**DRB CASE NO/PROJECT NO: 1005448**

Sketch Plat

**CITY OF ALBUQUERQUE  
PLANNING DEPARTMENT  
March 28, 2007  
DRB Comments**

**RE: Tract 289-C, MRGCD #27/sketch**

SKETCH PLAT OF  
TRACT 289-C  
AMENDED M.R.G.C.D. MAP NO. 27  
SITUATE WITHIN  
CITY OF ALBUQUERQUE  
BERNALILLO COUNTY, NEW MEXICO

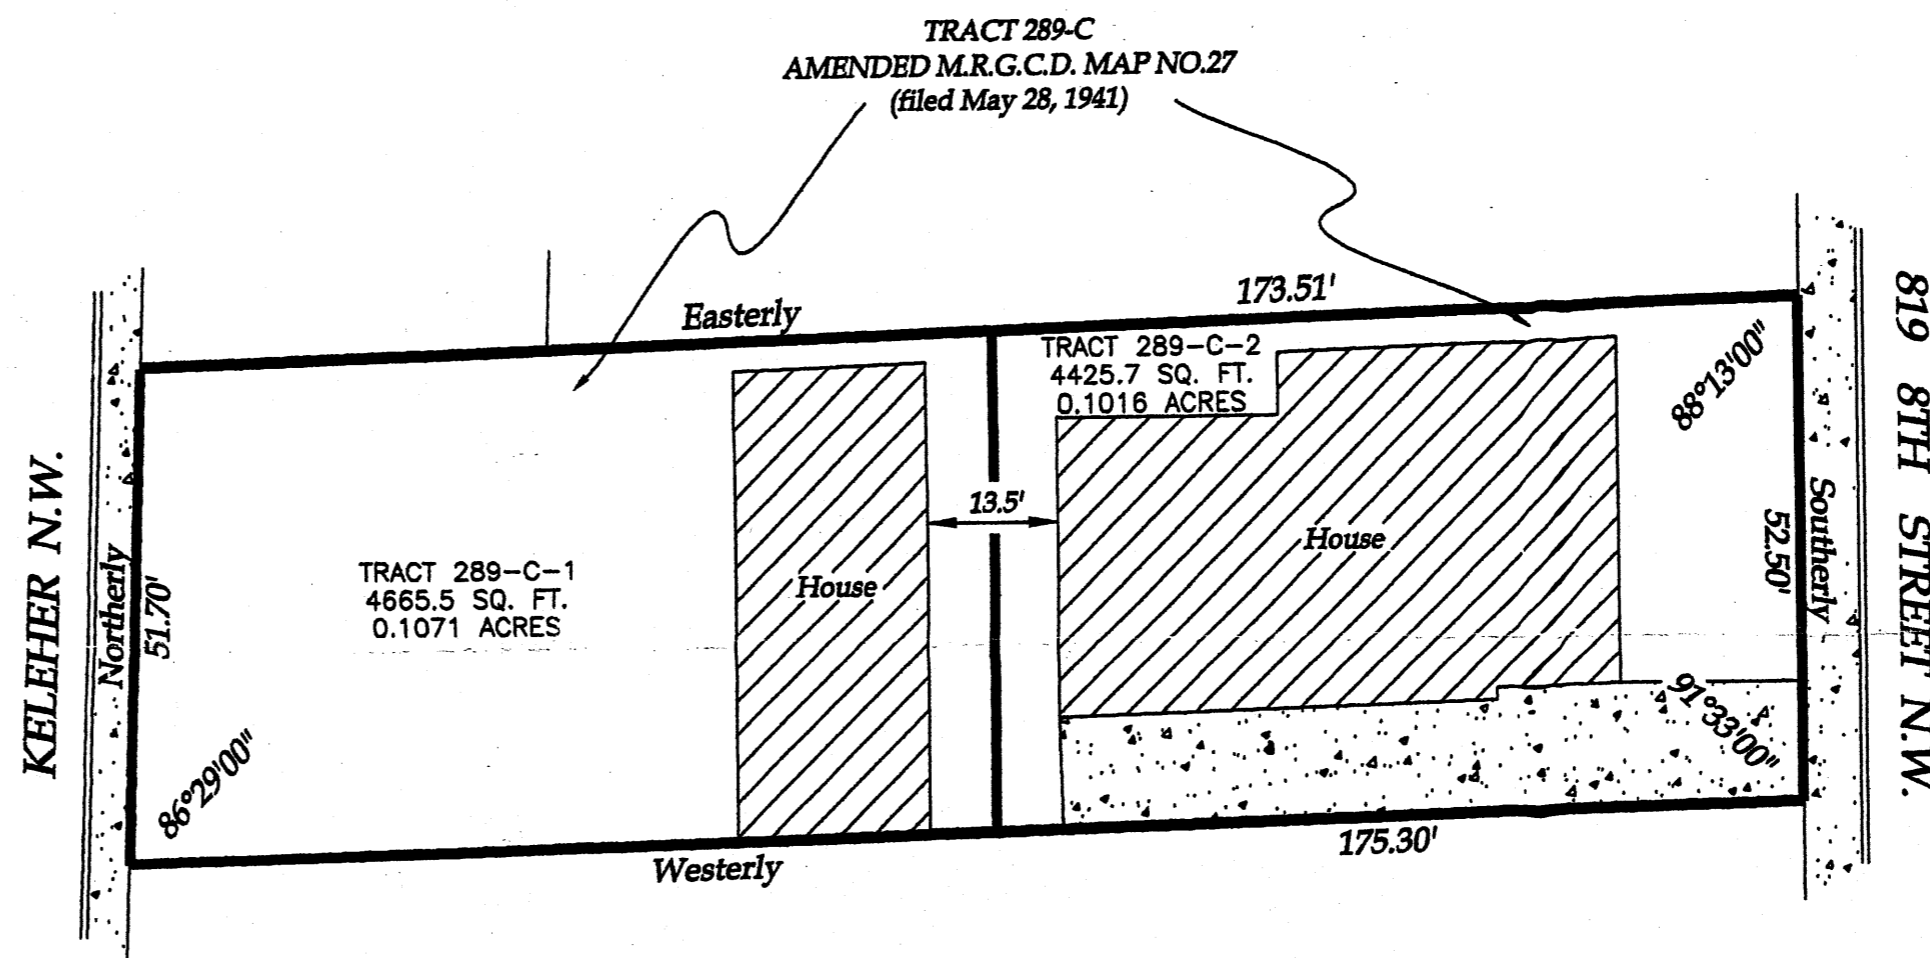
Are the houses shown on the sketch map existing structures?
